From: Daun Johnson on behalf of Planning.Responses
Sent: 15 February 2018 09:50
To: Planning Scanning
Subject: FW: A/3/18/PL - Land at Arundel Road/A27, Angmering - Change of use of land to storage (B8 Storage or Distribution)

From: Ross Leal
Sent: 14 February 2018 12:55
To: Planning.Responses
Subject: RE: A/3/18/PL - Land at Arundel Road/A27, Angmering - Change of use of land to storage (B8 Storage or Distribution)

Subject: FW: A/3/18/PL - Land at Arundel Road/A27, Angmering - Change of use of land to storage (B8 Storage or Distribution)

Title:
Site Access with Southern Visibility Splay

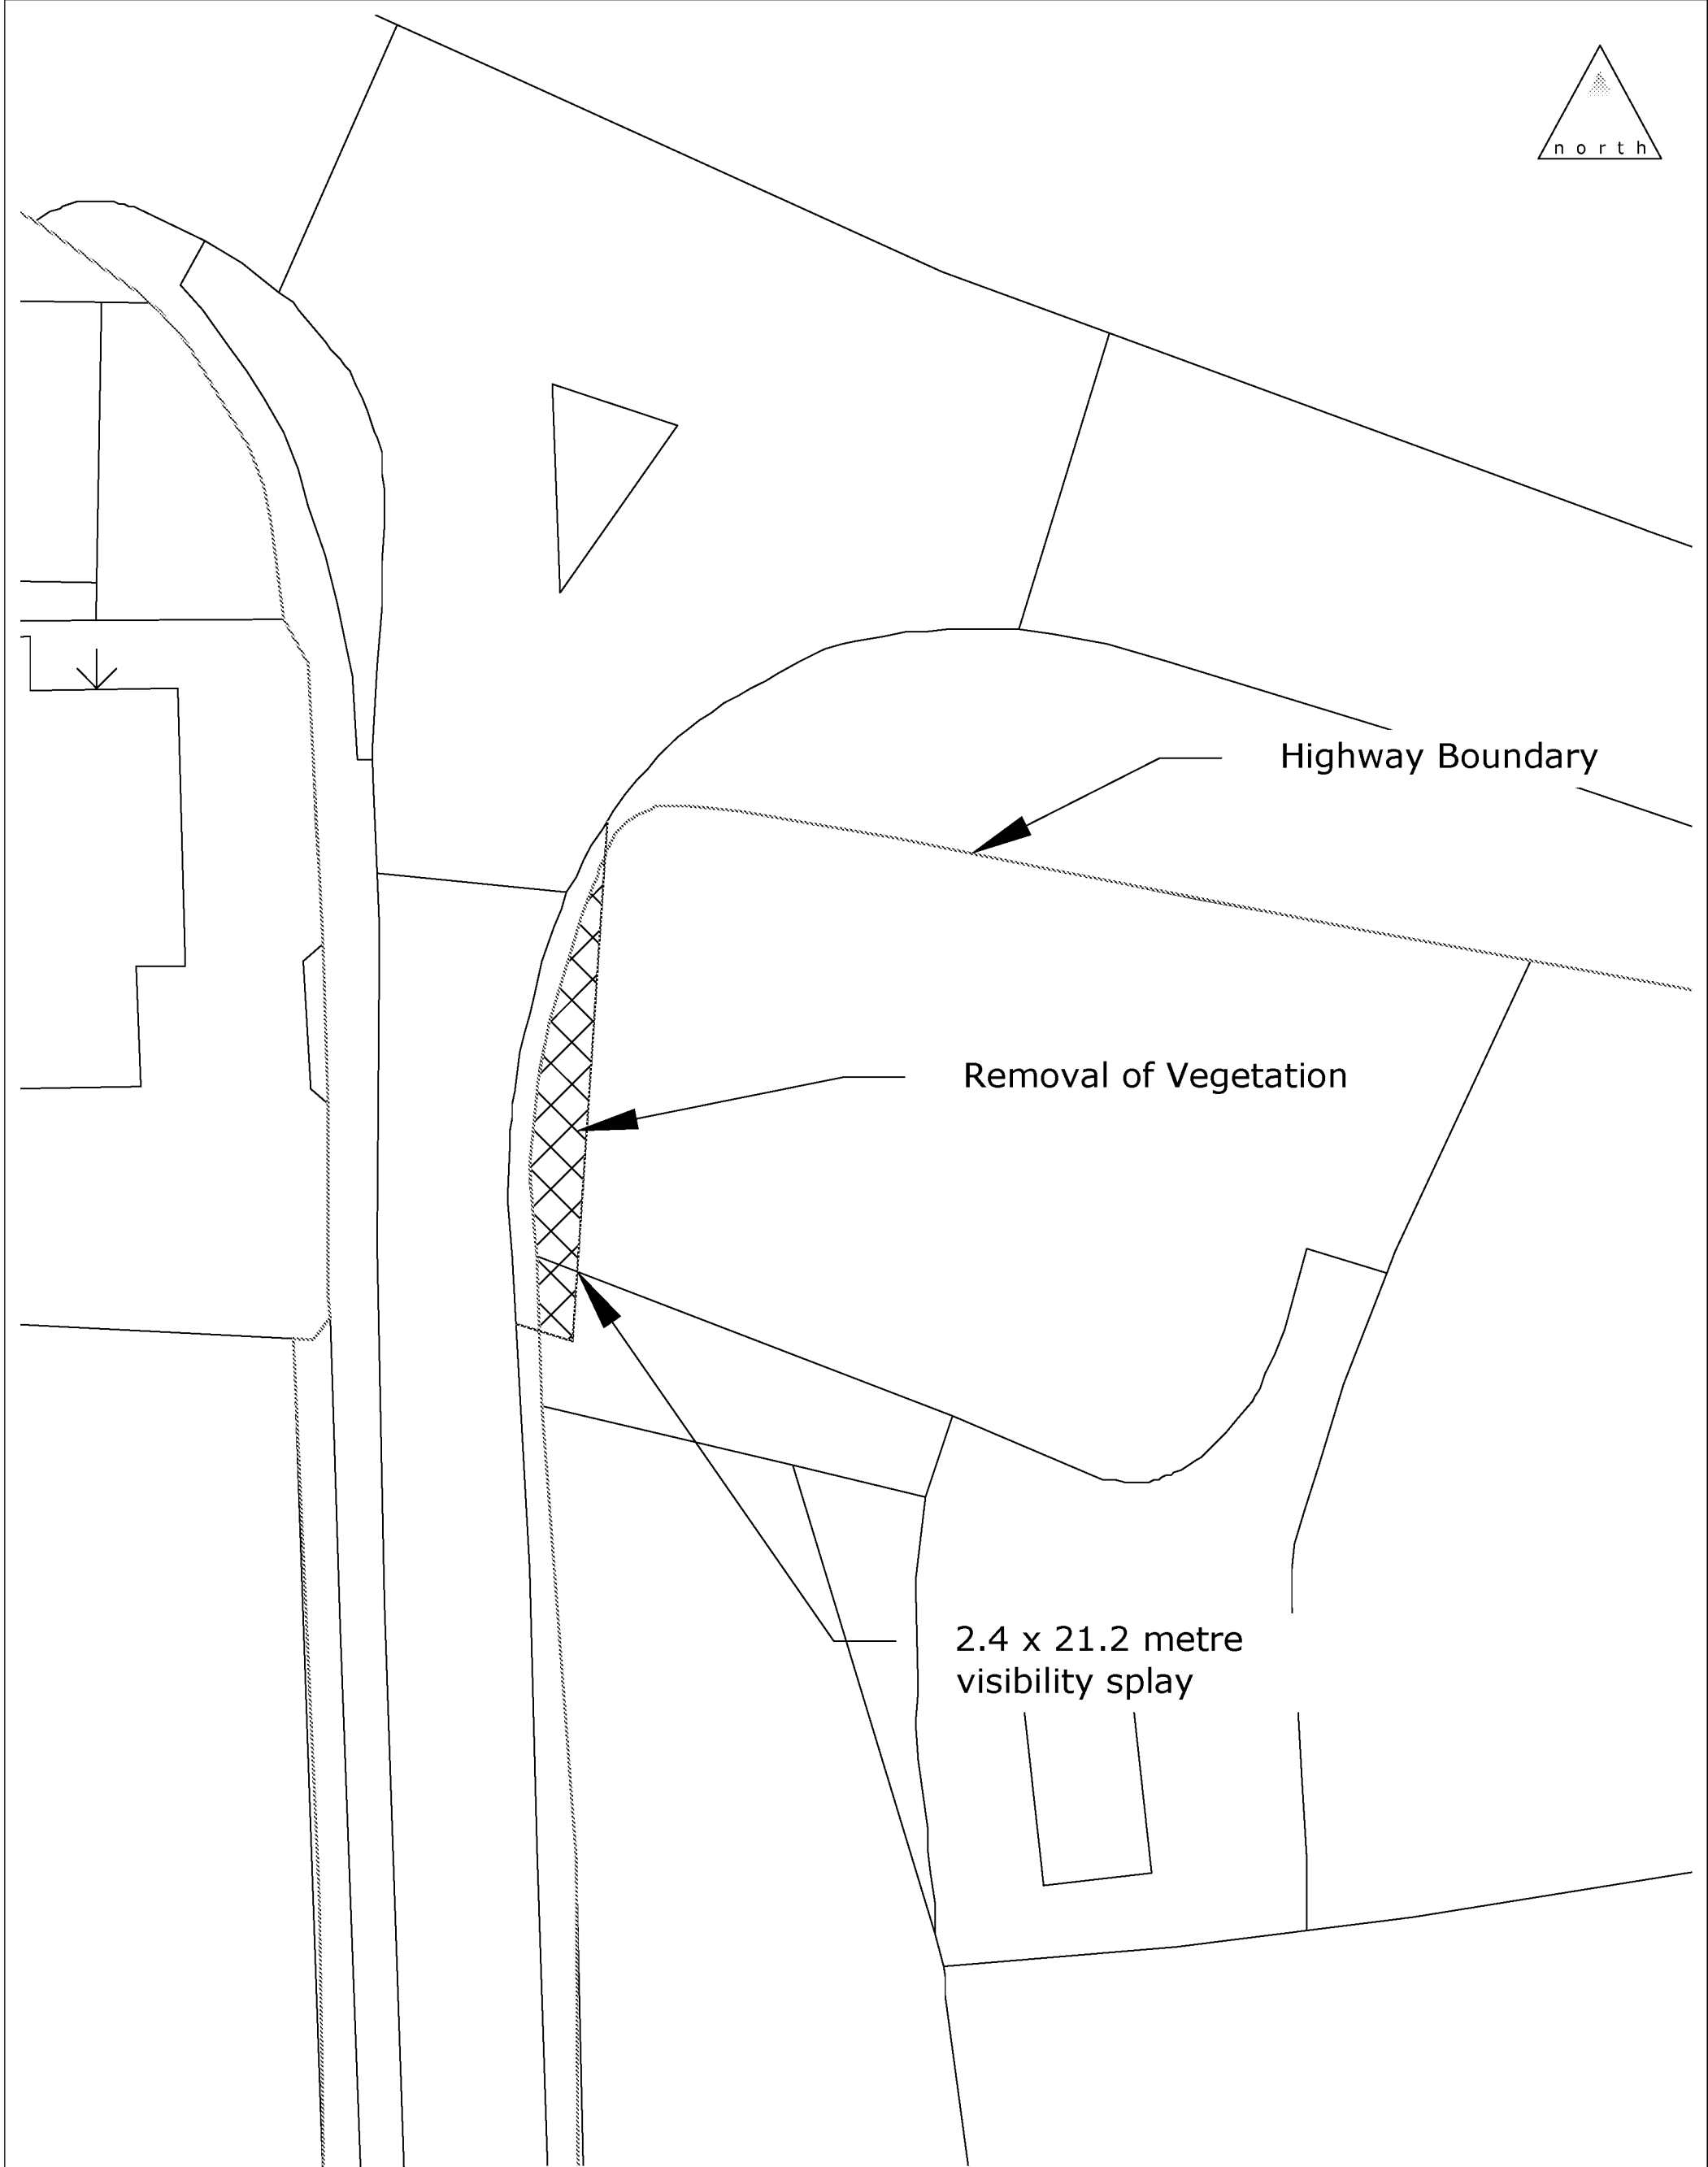
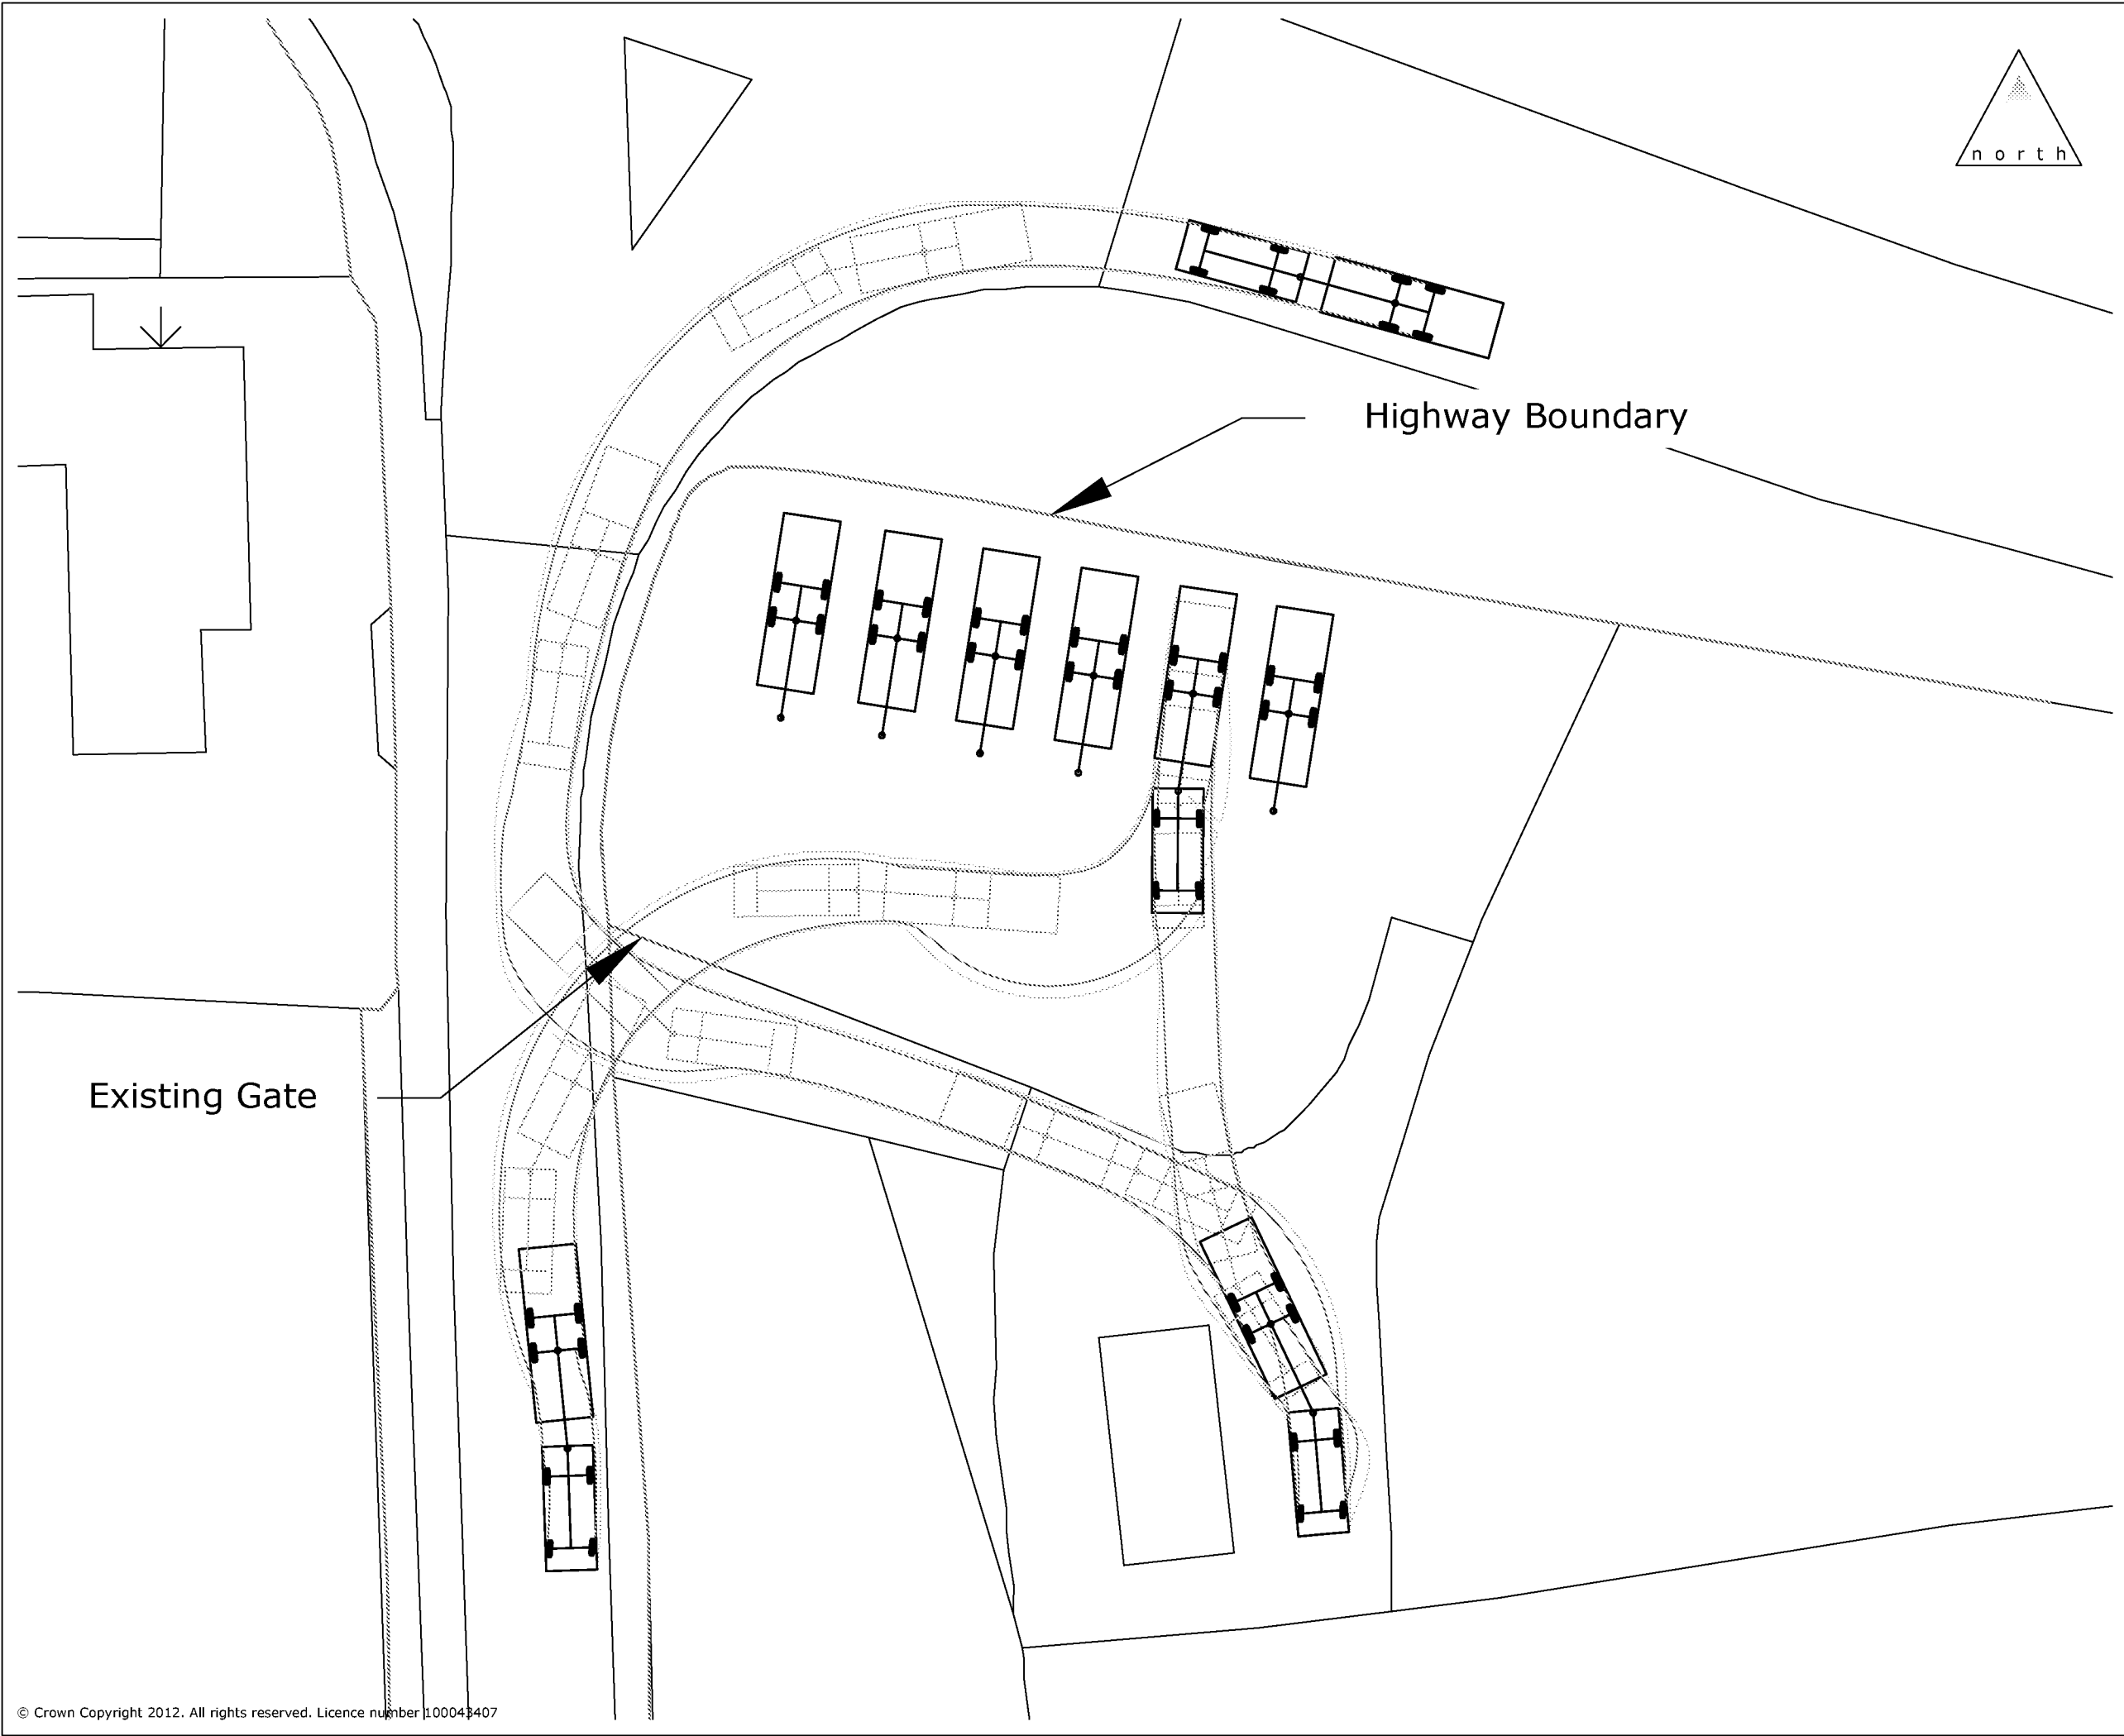
I will contact WSCC and ask whether it considers a further visit to this site is necessary. On my recent site visit I noted the hedging had been cut back, however I also noted that it was still in the same location, albeit perhaps lower in height on the north side of your access point. It therefore still obstructed visibility to some degree.

Apart from vehicle size, the issue here is also general visibility and remains so. The impact of possible hedgerow removal and potentially the tree are also issues.

It is possible that (if permission were to be granted) vehicle type/size could be restricted. However, the key issue here is whether visibility is satisfactory for smaller vehicles too and whether future potentially intensified use of this access is acceptable.
